# Tallawong Station Precinct South

Response to Submissions: Engineering Items

Client: Landcom

17-Oct-2018

Last saved by: D:\T01M(2018-04-11) Last Plotted: 2018-05-18
Filename: \\AUSYD1FP001\PROJECTS\60558549-SHT-00-0000-CI-0123.DWG

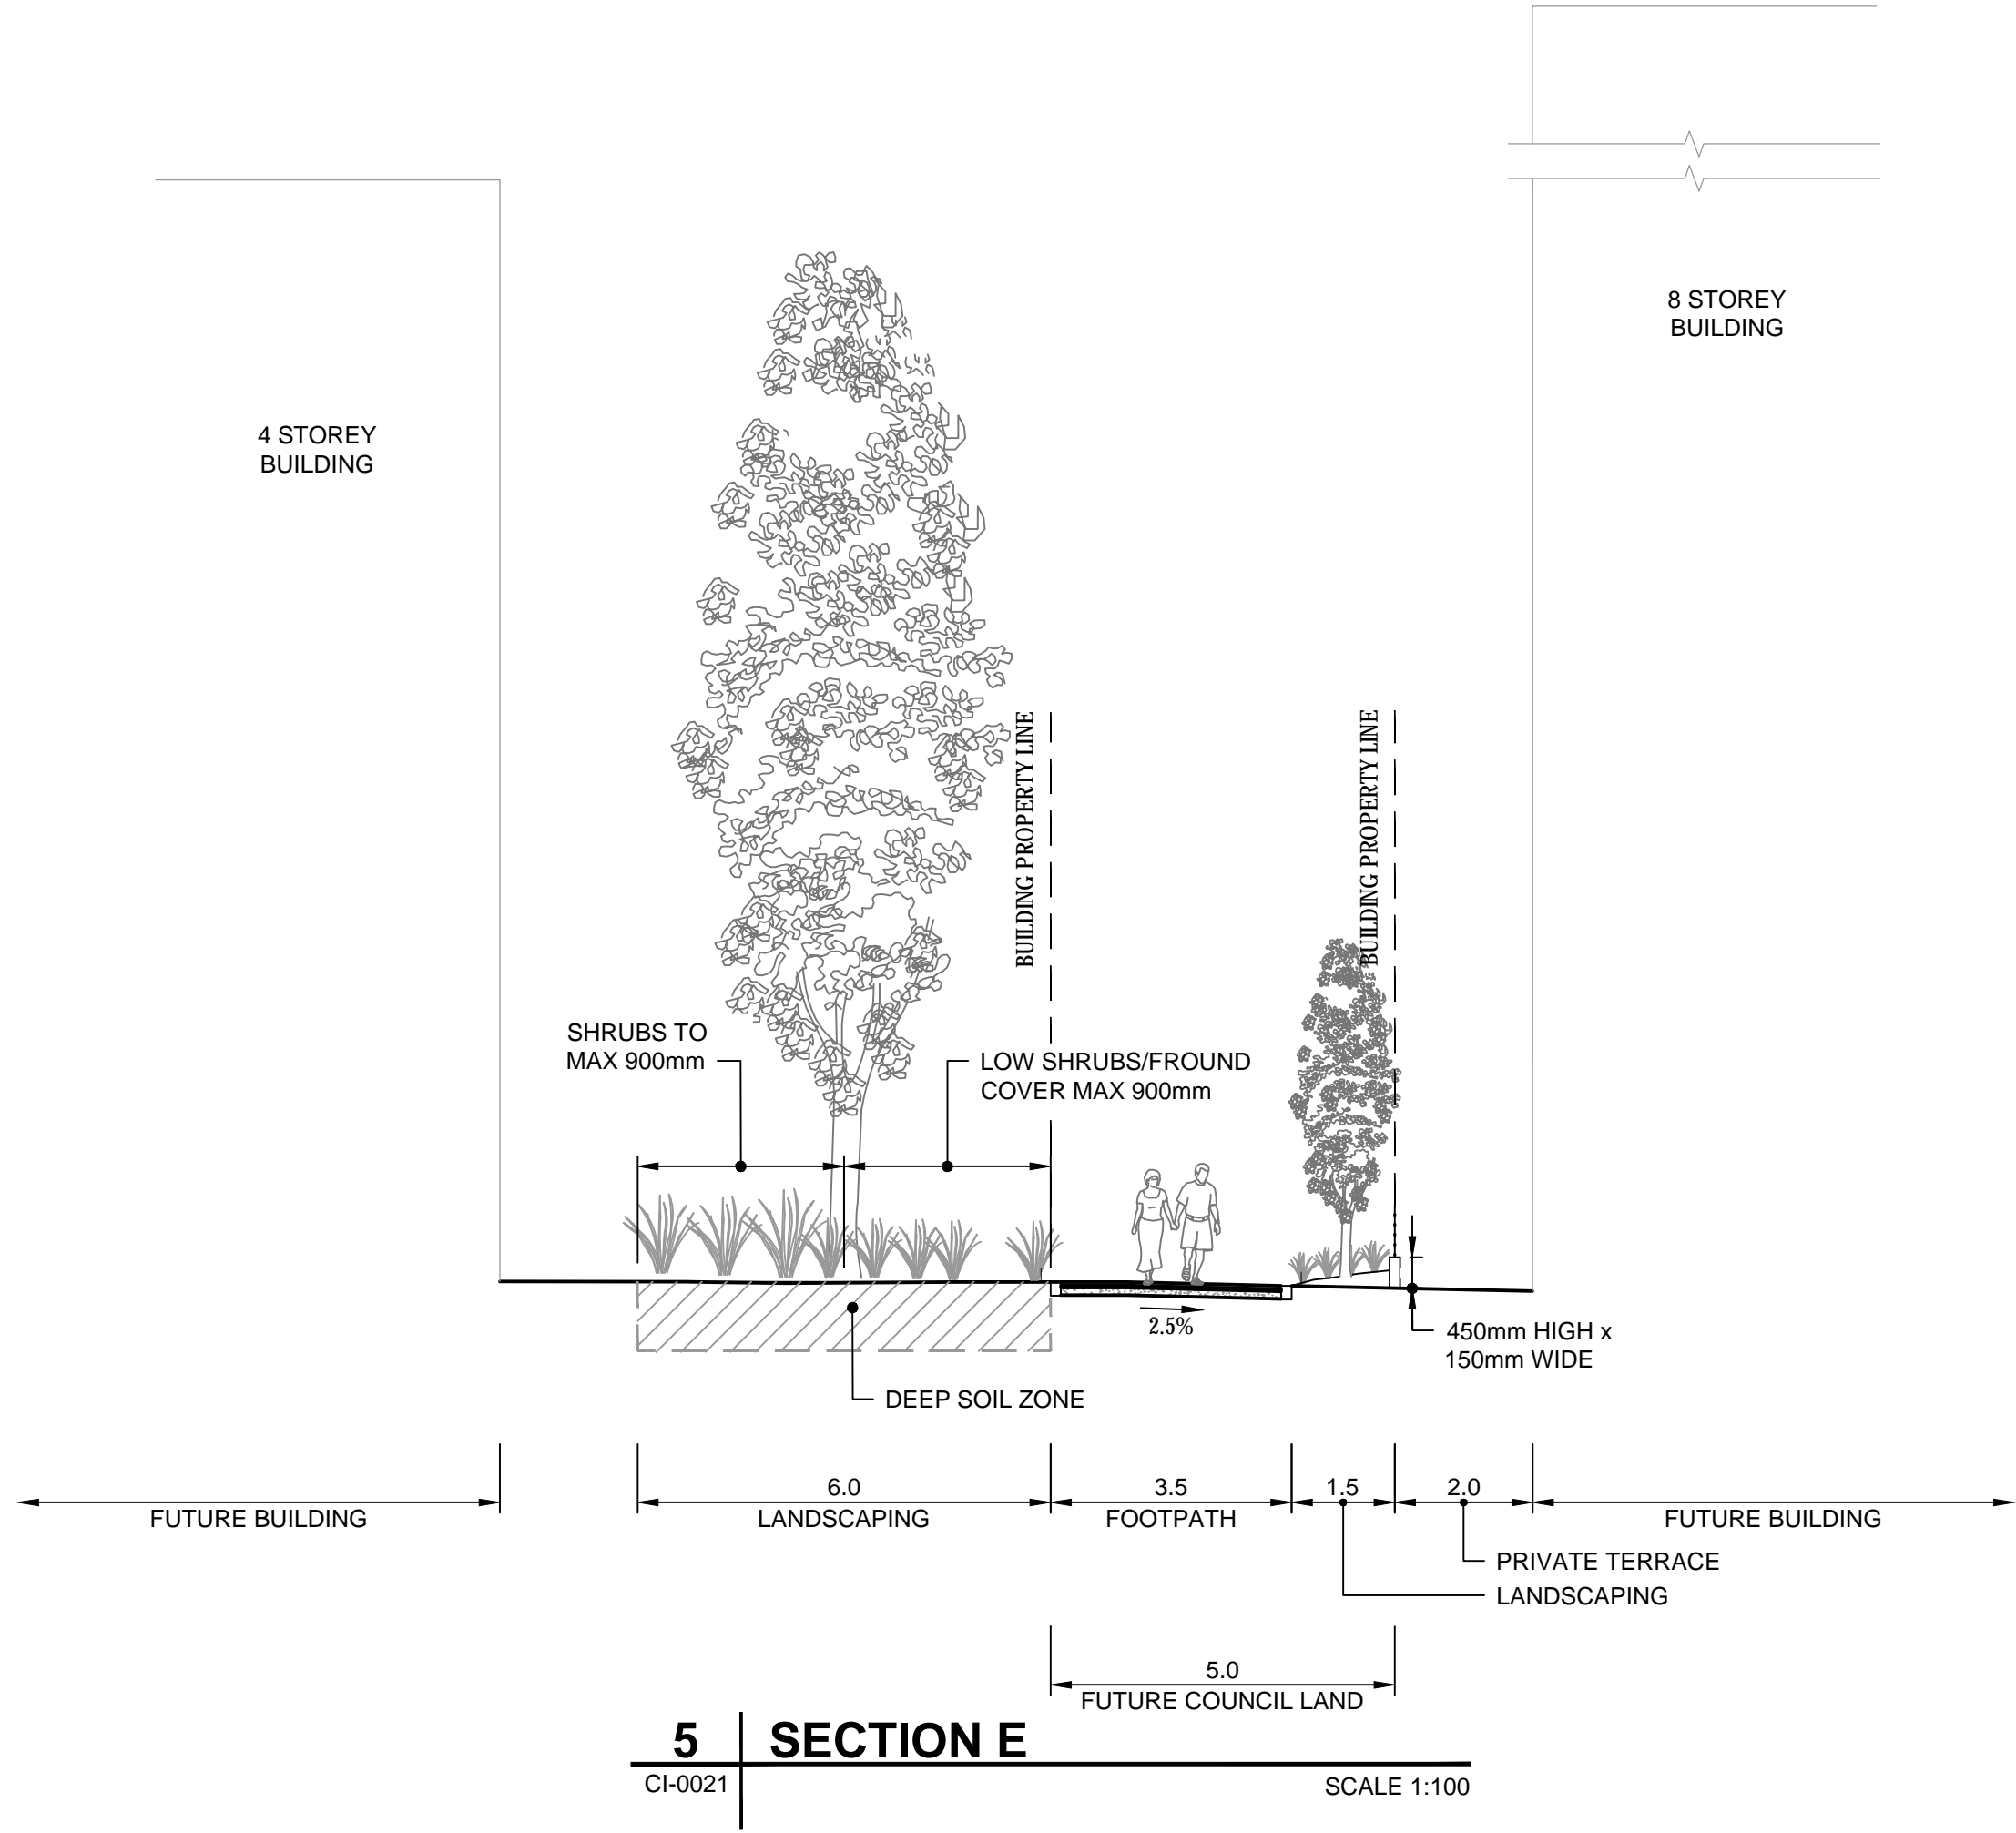
- 60558549-SHT-CI-0121 – Section B has been amended to remove the parking reference where the cycle lane is located, footpath has also been correctly shown as 3m width;
- 60558549-SHT-CI-0123 – Section F has been amended to show the correct setback distance of 10m; and
- 60558549-SHT-CI-0123 TYPICAL – In consultation with Blacktown City Council (BCC), the footpath width in Section H has been reduced to 3m to allow a 2m landscaped area.

All road verge widths are a minimum 3.5m (when including footpaths) and local road footpaths are a minimum of 1.6 m wide, refer to the following civil drawings:
